Subject: FW: LU/370/19/HH

Having gone through the plans in depth there is a large amount that needs doing. Please see below for all the changes that need to be made in order for the plans to align.

EXT^N To BOUNDARIES. FLUSH.
SCALE 1:500

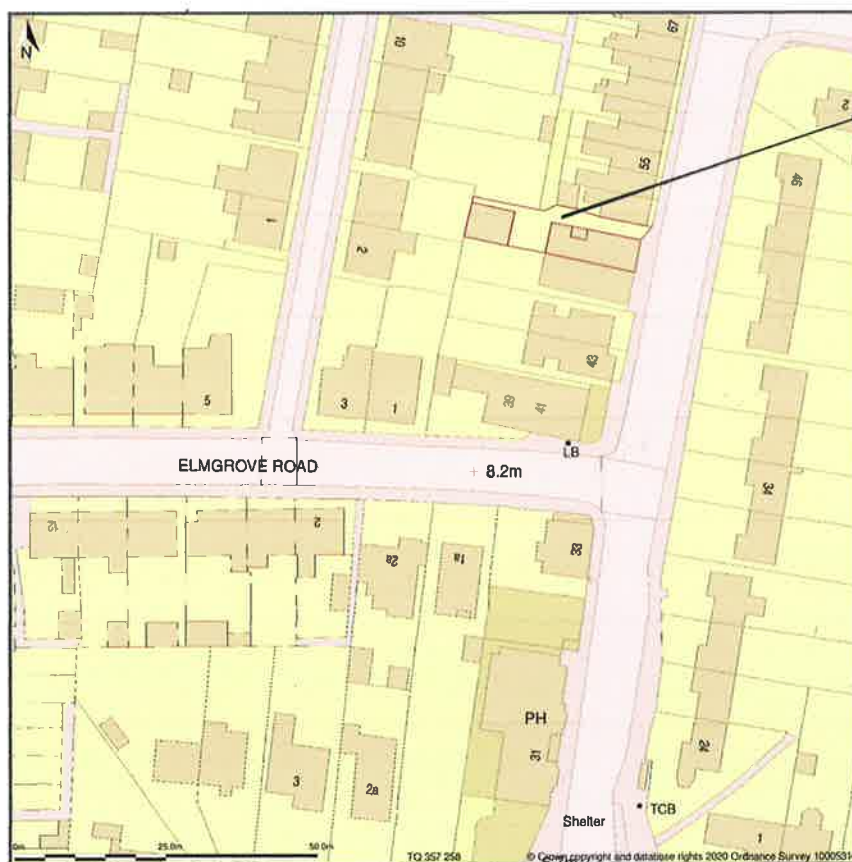
The block plan needs to be updated to show the first floor side extension to the office/flat.

Existing Ground Floor Plan
(1:100)

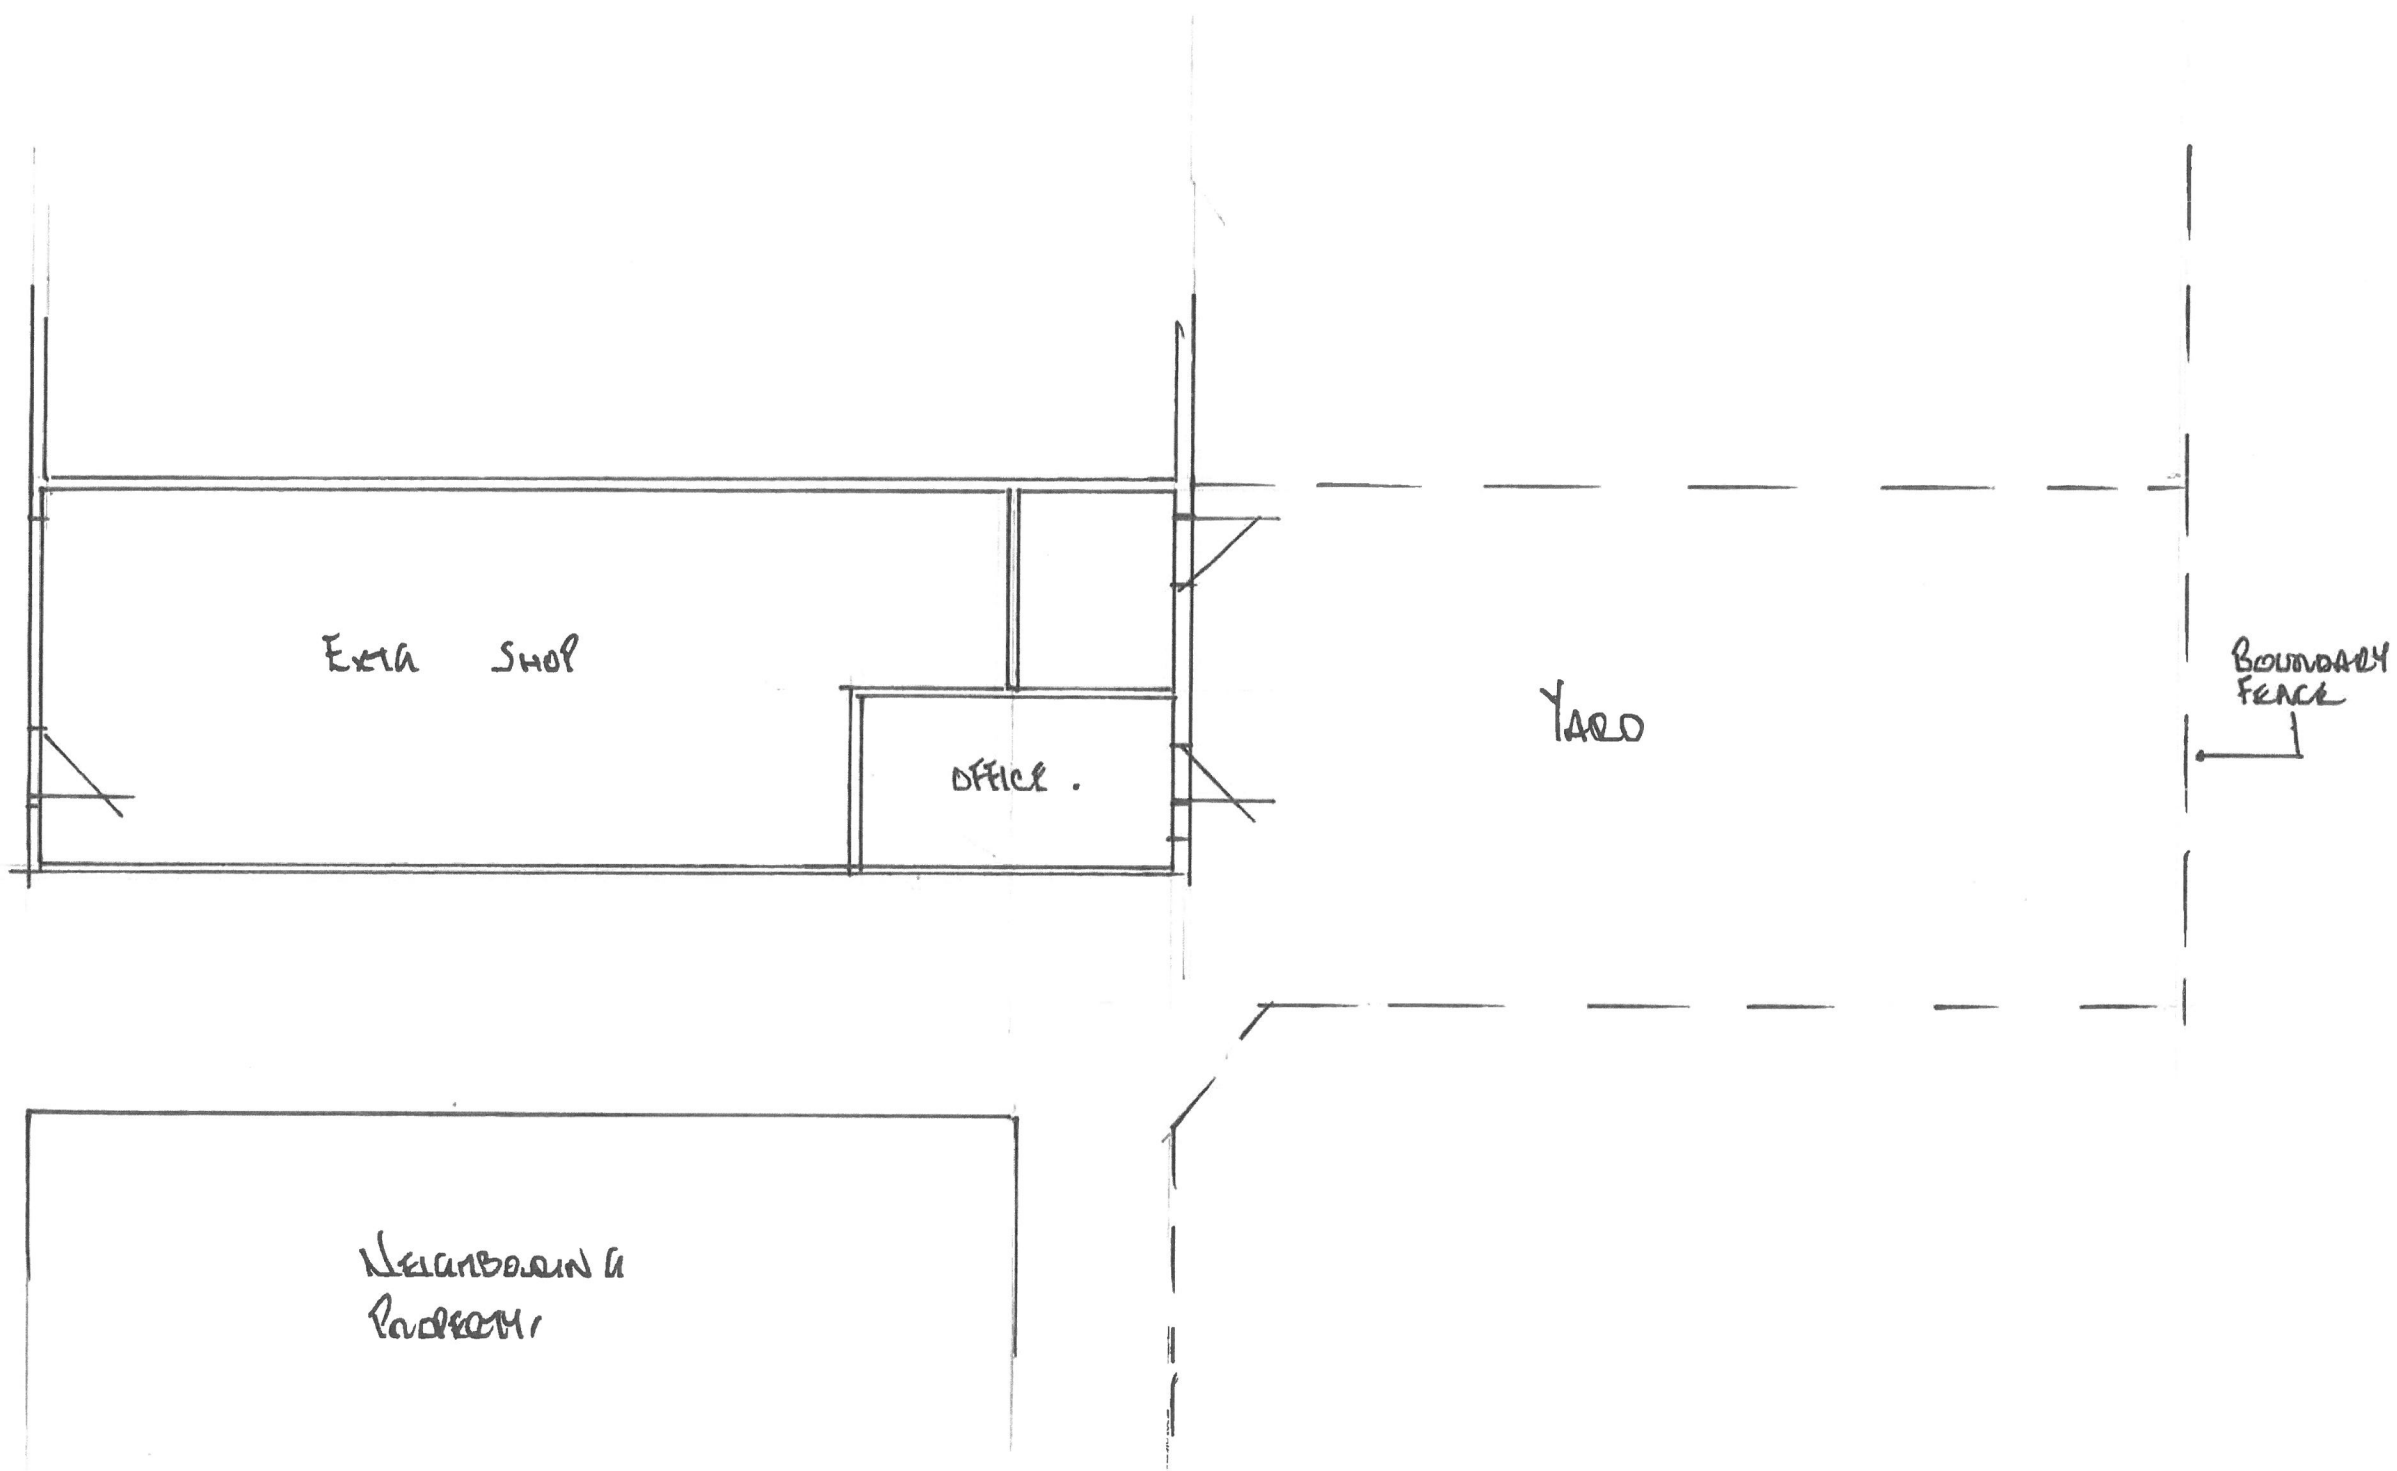
- The window sizes need checking.
- Flat/office needs to be clarified.

ALL AS EXISTING.
1:100.

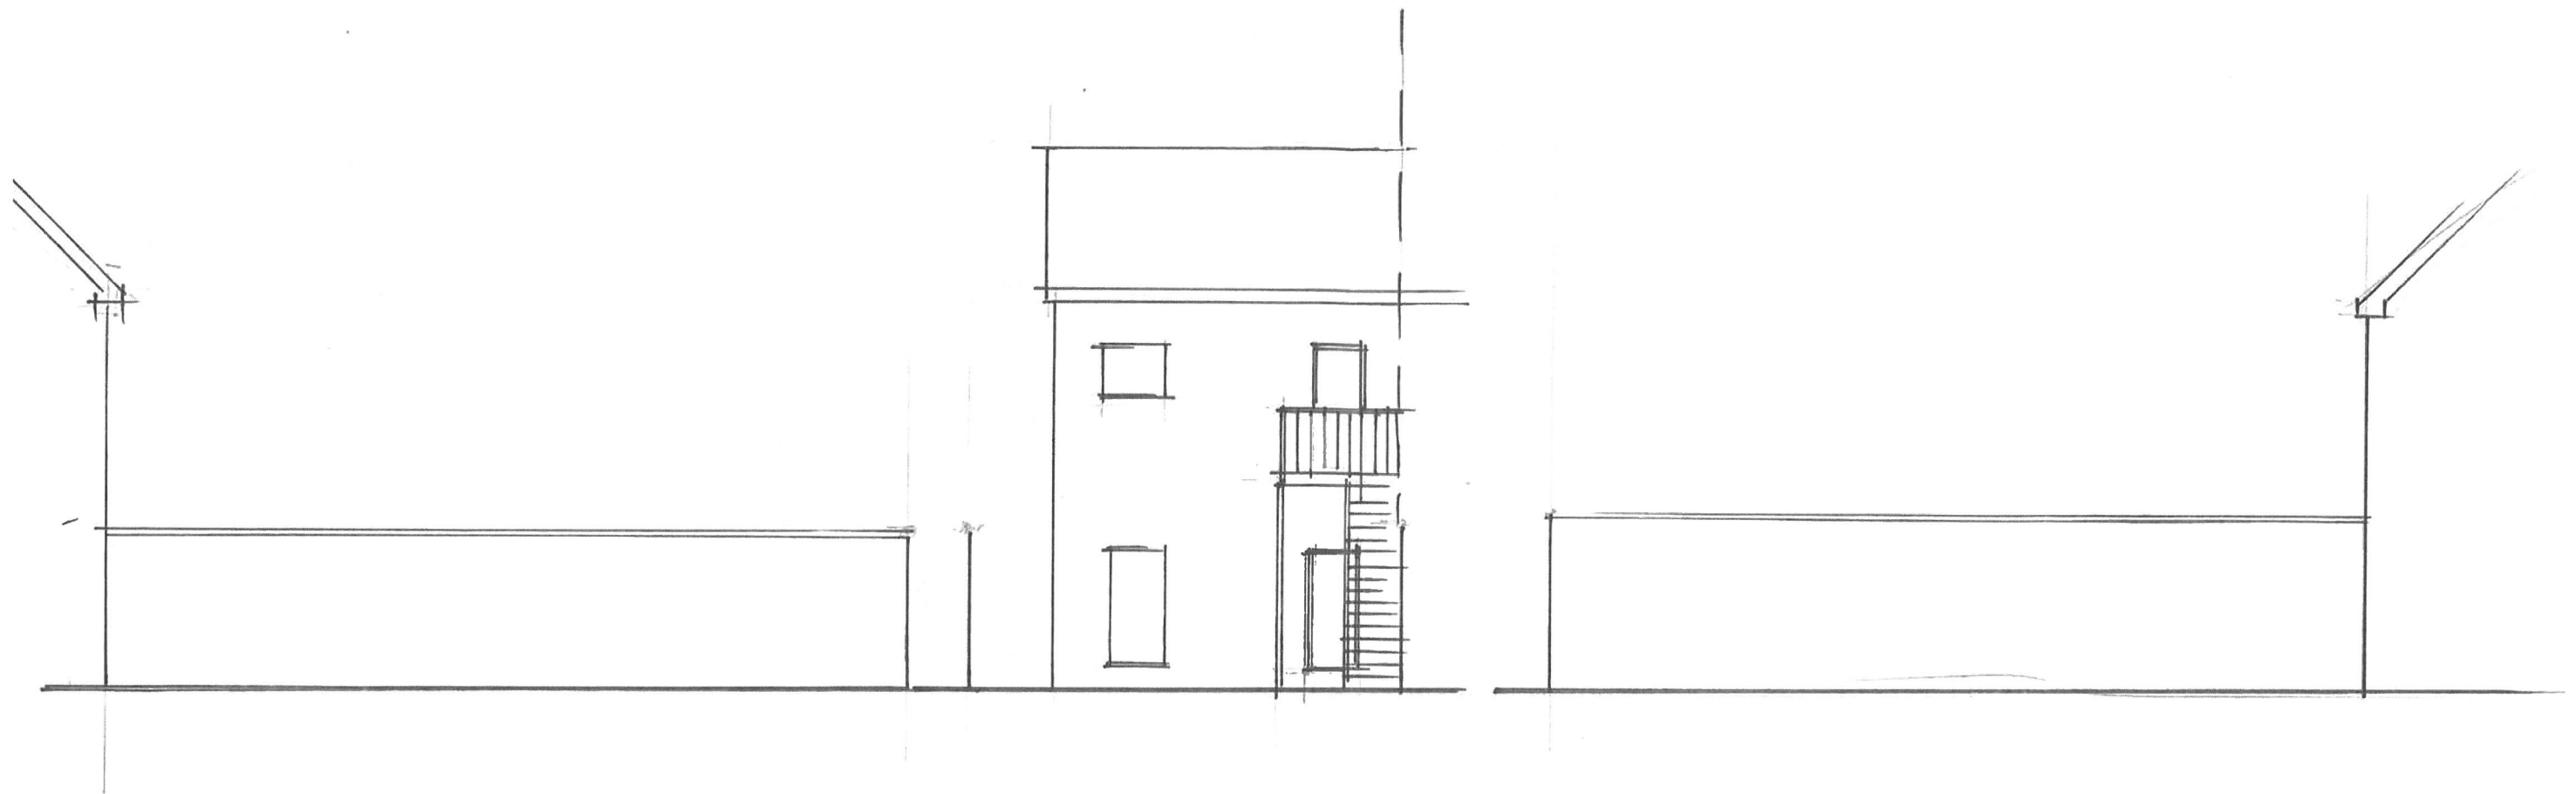
- Measurements need to be put in as not scaled correctly.
- The lean to roof needs to be shown.

PROPOSED GROUND FLOOR PLAN.
(1:100)

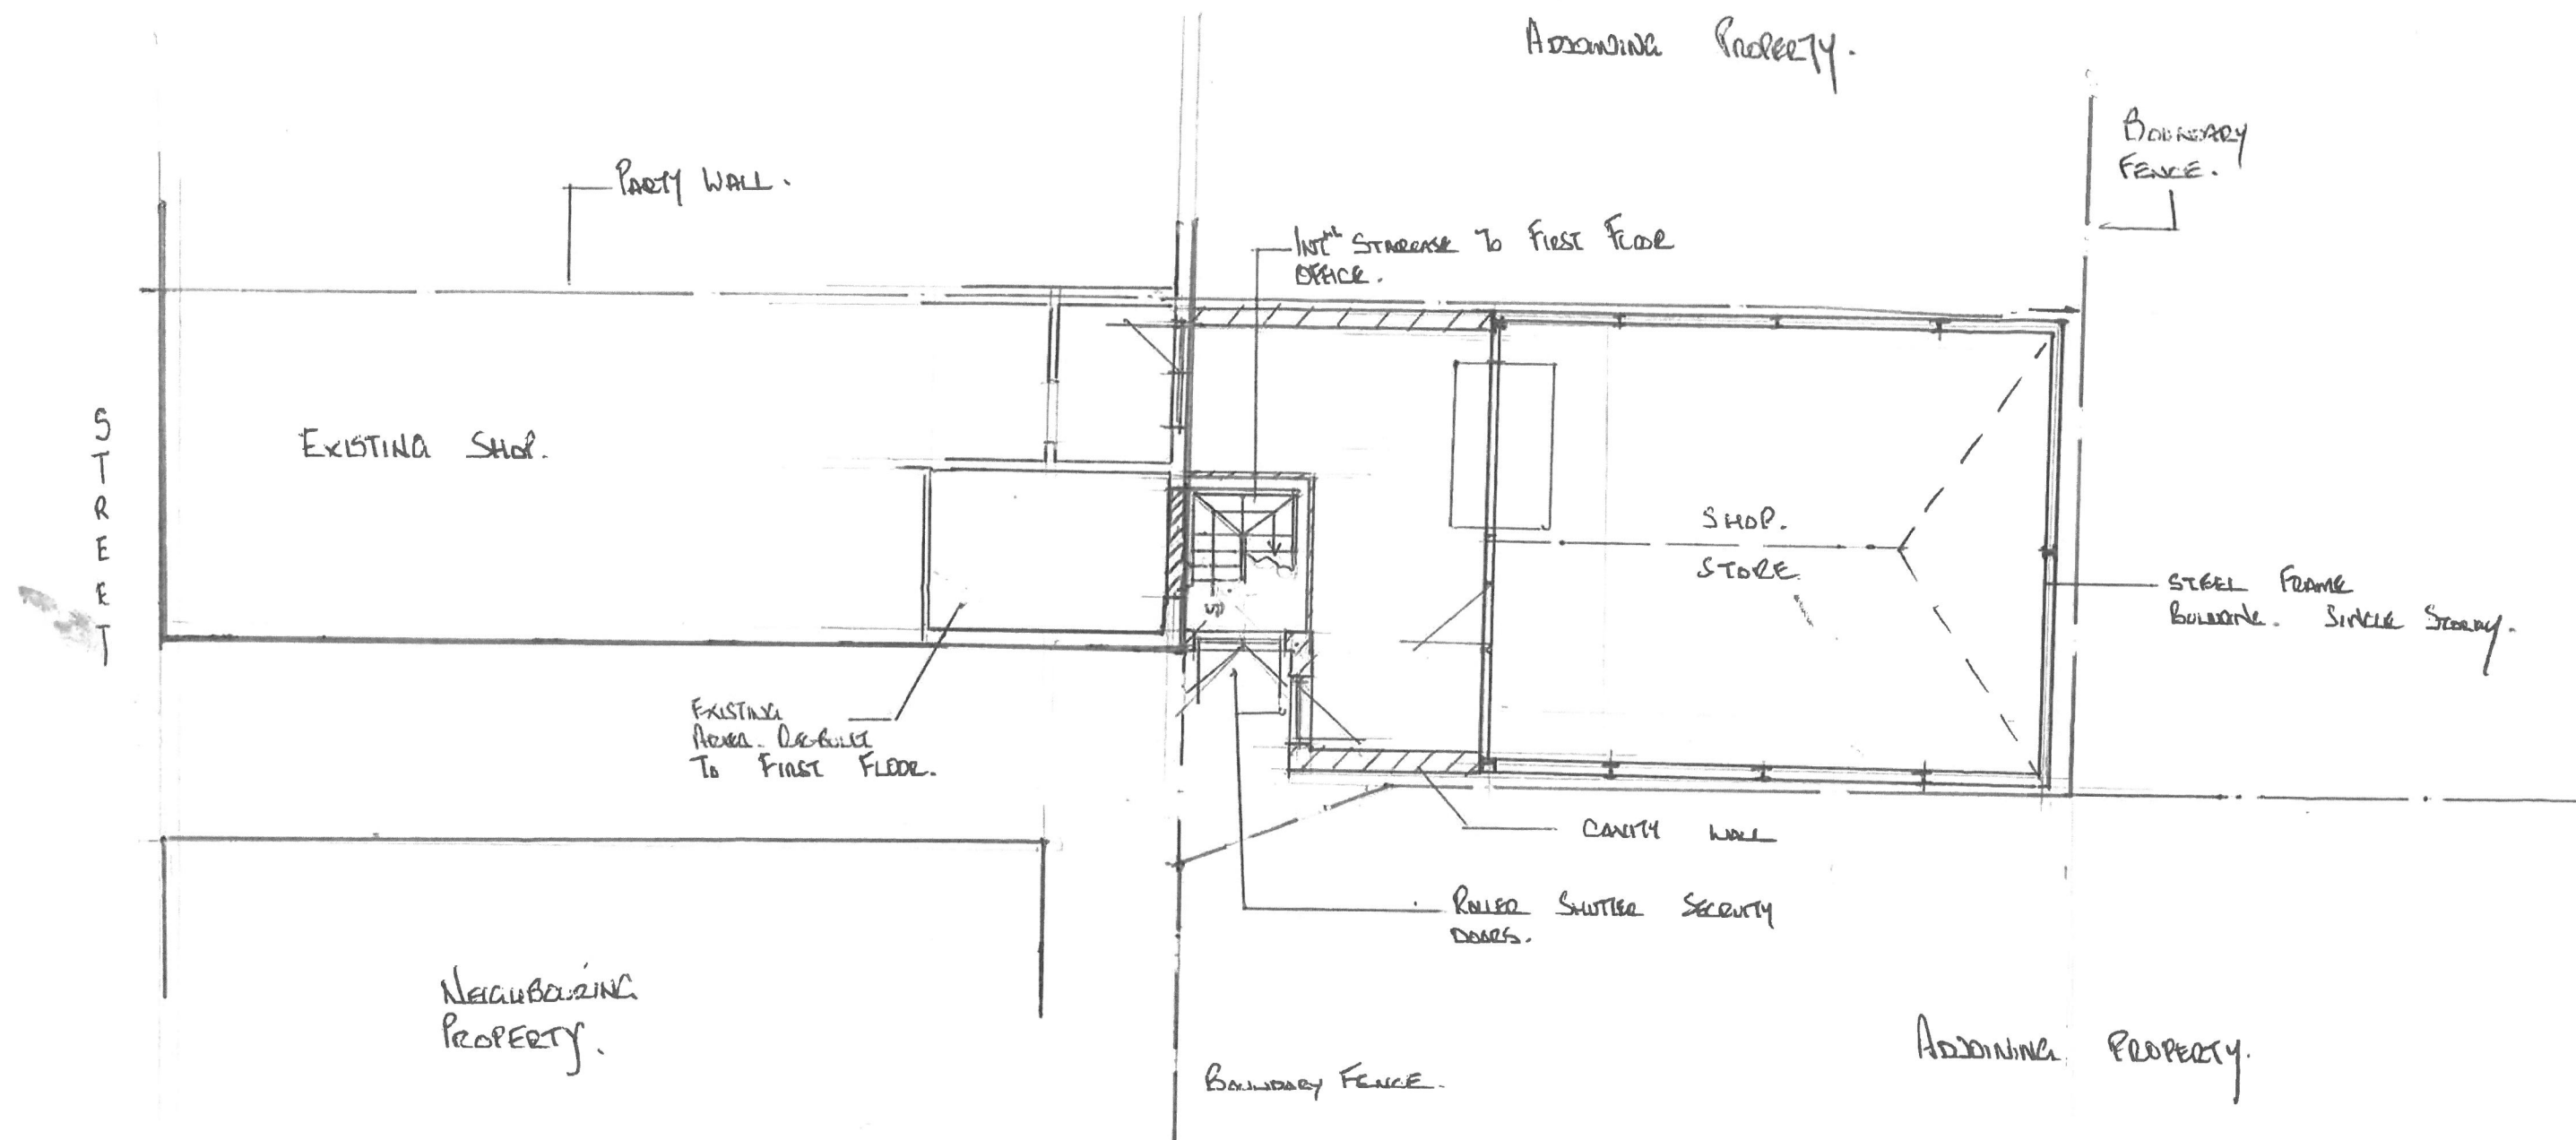
- The roof is currently shown to be overhanging the boundary to the north.
- The roof lights need to be shown.
- There is also no access currently shown to the proposed store.

[1:100]
[As Proposed.]

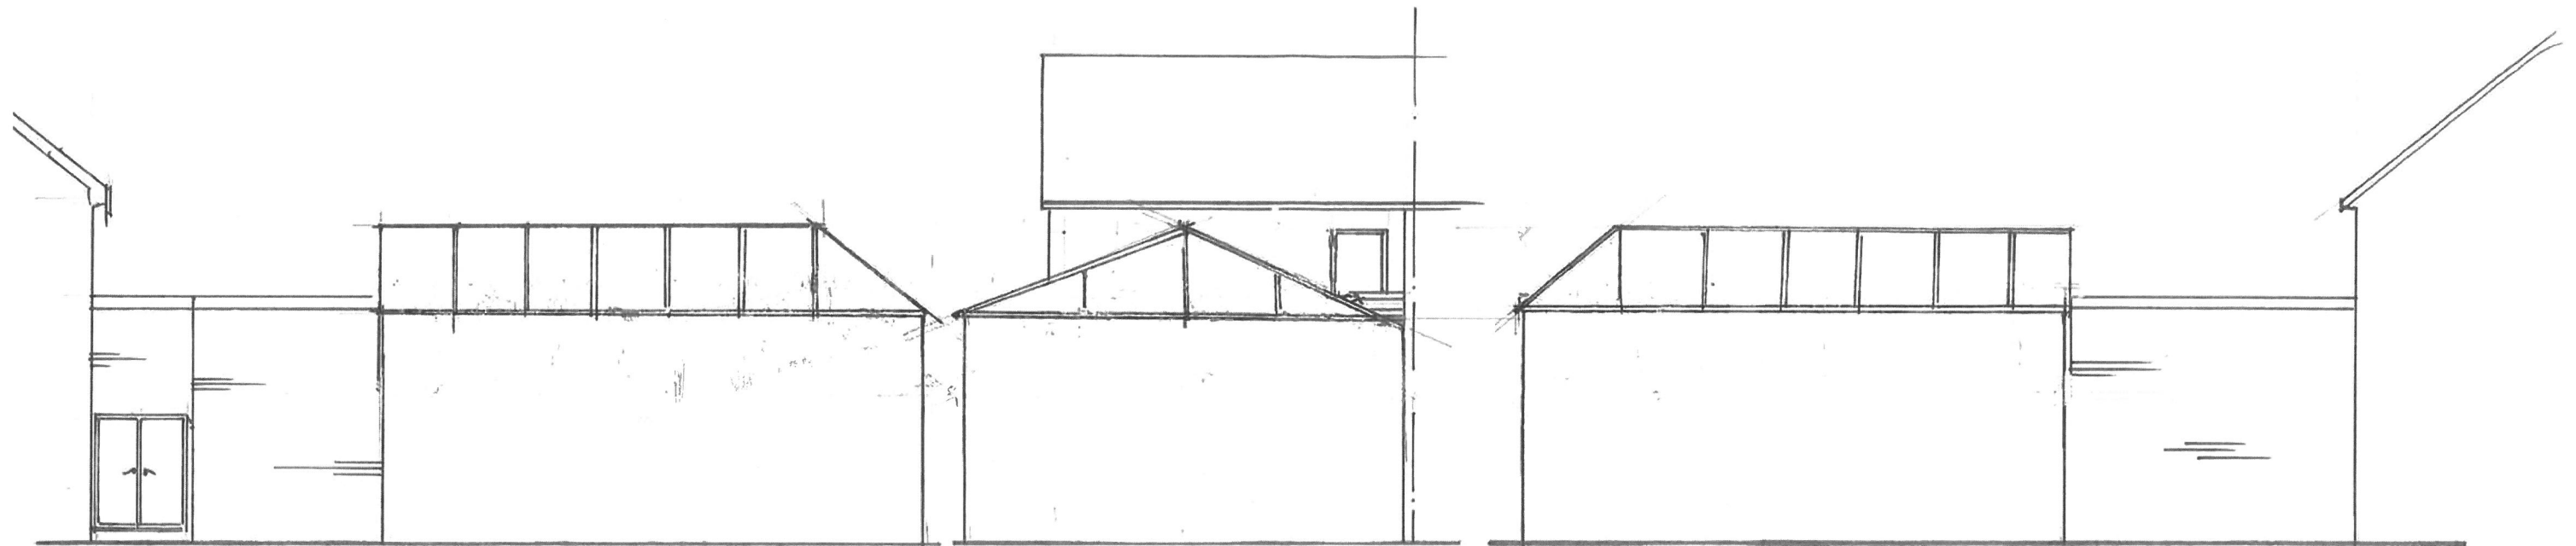
- There needs to be a title to the drawings (Proposed Elevations Scale 1:100).
- North and South elevations need to have the existing pitched roof shown (the one above the flat).
- The front elevation roof shape needs to be North to South (with the gables not visible).
- The North elevation needs to have the dotted line to show the floor level.
- The open area at the first floor needs to be labelled clearly and dimensions added to show the dwarf wall and then fencing above.
